CITY OF ALBUQUERQUE

RE: Tin Can Alley
6100 Alameda NE
Grading and Drainage Plan
Engineer's Stamp Date: 02/20/19
Hydrology File: C18D086

Based upon the information provided in your submittal received 02/20/2019, the Grading and Drainage Plan **is not** approved for Building Permit and Foundation Permit. The following comments need to be addressed for approval of the above referenced project:

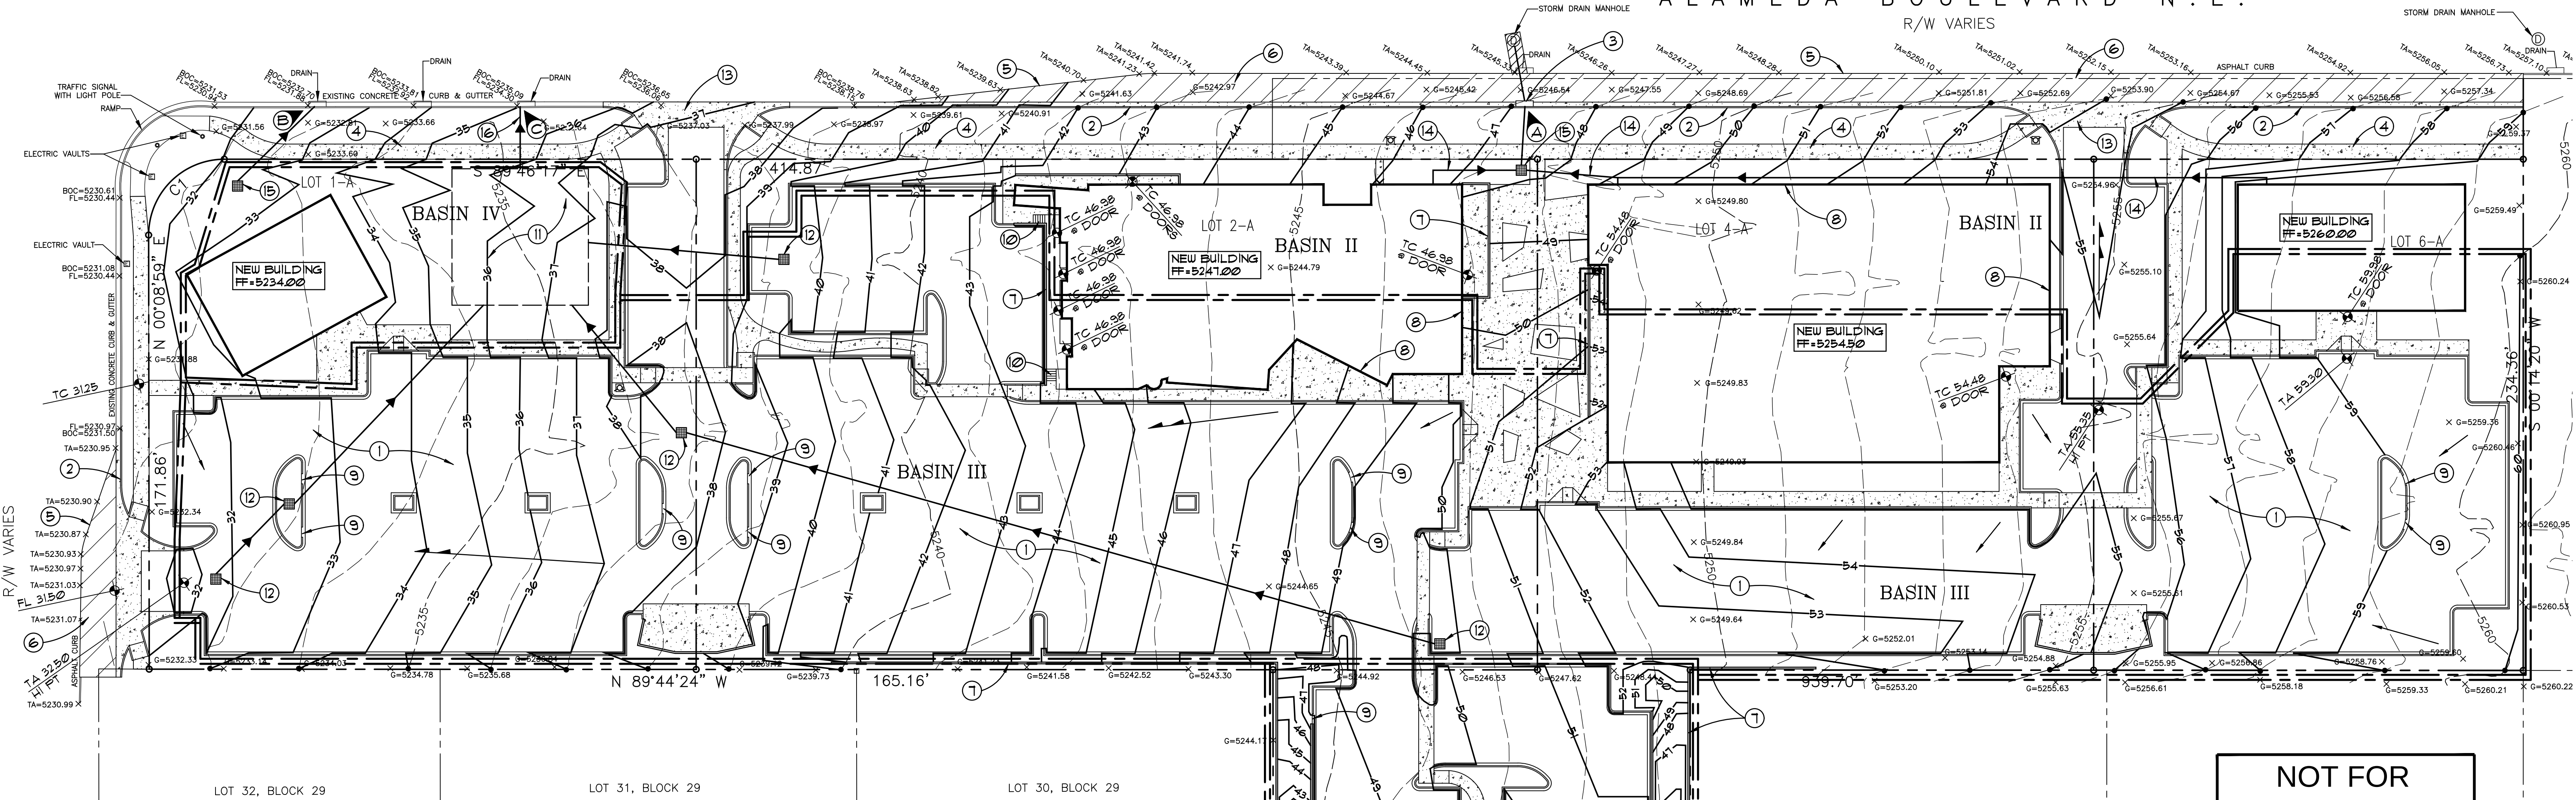
1. Overall G & D. Please show what is being constructed with this Building Permit (the limits of construction). Will a permanent drainage system or a temporary retention pond (100 year 10 day volume) be constructed? Whichever the solution is built, please include this in the construction plans.

2. Overall G & D. Please show and label all work within the R.O.W. as being constructed under CPN # 766382.
3. Overall G & D. Please show all future development with a lighter linetype and label as future development.

4. Please also show the parking spaces along with the ADA spaces.
5. Please show the trash enclosures. For trash enclosures serving food service developments, demonstrate control of liquids from dumpster areas per DPM Chapter 22.9.E, Table 1 by containing runoff from the dumpster area and discharging to the sanitary sewer. If this information is on the utility plan please provide it, or show on the grading plan.

6. Where is the oil/water separator from Detail #5 from Sheet C201? If this was to be used in the dumpster area, please see Comment #5 and remove this as it is not appropriate use in a dumpster area.

7. Please provide the drainage calculation for this phase of the construction.
8. Please show the drainage area for each stormwater quality (SWQ) pond, provide the stormwater quality (SWQ) volume calculations including how much is required and how much is provided for each drainage area to the pond, and please label all stormwater quality ponds with the provided volume.
9. Please provide the weir calculation for the 4' curb cuts. Please verify the size of curb cuts needed. If a smaller one can be used then please change the calculation and labeling to reflect this.
10. Please revise the detention volume for the underground facility. The hydrograph that was submitted in the Conceptual Grading Plan was incorrectly calculated. Please see the section from the DPM.

12. Please show a buildable underground detention facility with all needed details.
13. Please include all calculations for the outfall structure/orifice plate whichever is being used to limit the discharge rate.

14. Please show how the runoff from the proposed phased paving area is going to be stopped from traveling to the adjacent undeveloped area. Also provide any supporting hydrologic calculations.

15. Please revise the Hydrologic Grade Line (HGL) calculations for the proposed storm system from the existing storm drain truck line in Alameda through the underground system to the sump inlet near the drive entrance to San Pedro Blvd. Using DPM procedures including Bernoulli's equation and minor losses applied to the energy grade line. Also Include the Energy Grade Line (EGL) elevations. The normal depth calculations submitted in the Conceptual G&D Plan are not adequate for the final construction plan approval.
